Reviewed for Fire Code Compliance
 Leslie Jackson
12/07/2023 8:19:23 AM

FOOD LION #1237

FIRE ALARM WIRING PLAN

DRAWING NAME
FIRE ALARM WIRING PLAN

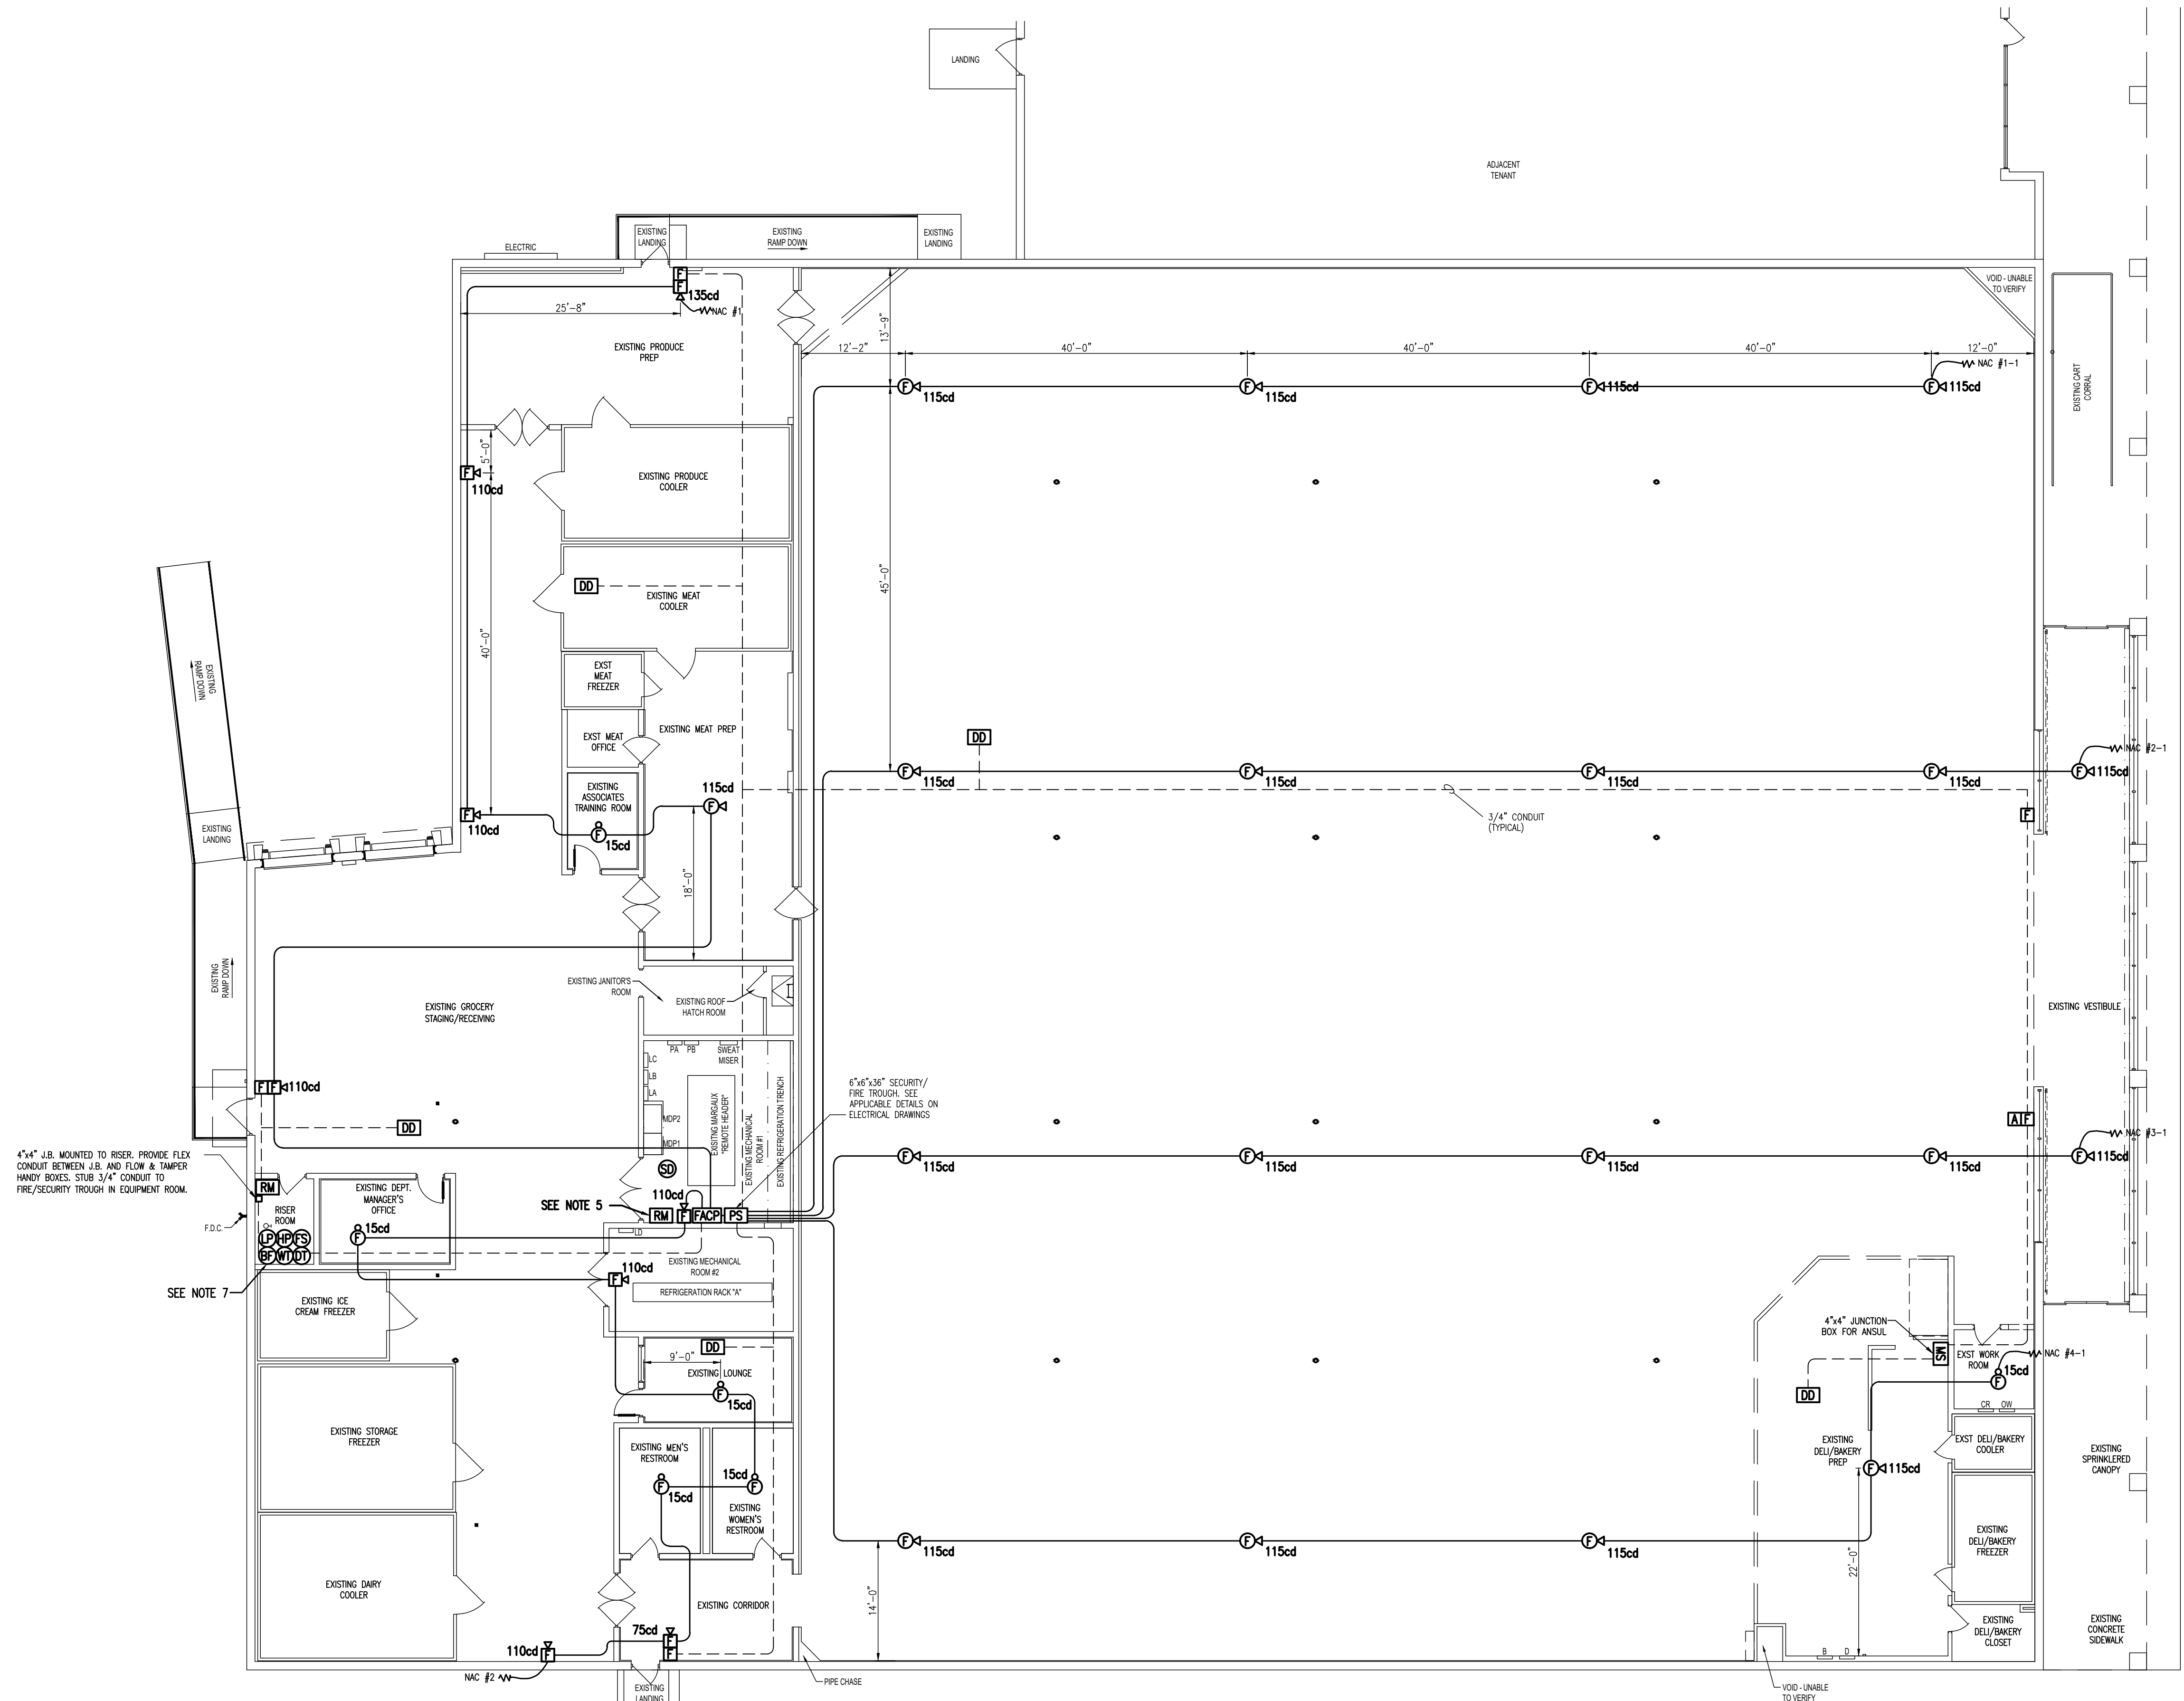
VOID-UNABLE TO VERIFY
